Application No: 19/01643/DISC-2

Proposal: Discharge of Condition 20 (Site Environmental Management Plan), 21 (management, storage and/or disposal of spoil), 25 (archaeological Written Scheme of Investigation), 26 (on-site renewable energy provision) and 27 (34 space public car park) of 15/01326/OUT

Location: White Post Road Banbury

Transport Development Control

CARPARK LAYOUT

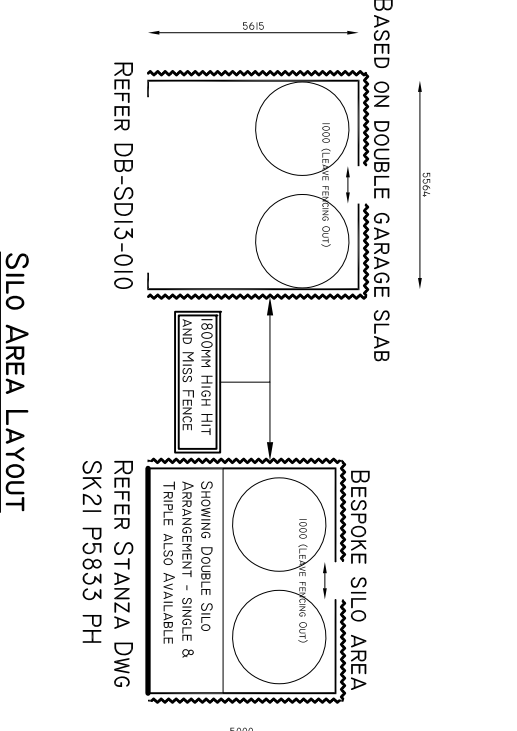
It came to our realisation that the details submitted pursuant to discharge of Condition 27 do not fully meet the requirement. The condition states, *'No development shall commence until full details (including construction, specification) of the new 34 space public car park adjacent to White Post Road (shown indicatively on Drawing No: 1361/22 Rev E) together with a timetable for its completion have been submitted to and approved in writing by the Local Planning Authority. The new car park shall be completed in accordance with the approved details and retained for free public use thereafter as a car park.'*

Whilst the application has presented an agreeable layout plan for the car park, the submitted documents do not include a timetable for completion of the car park.
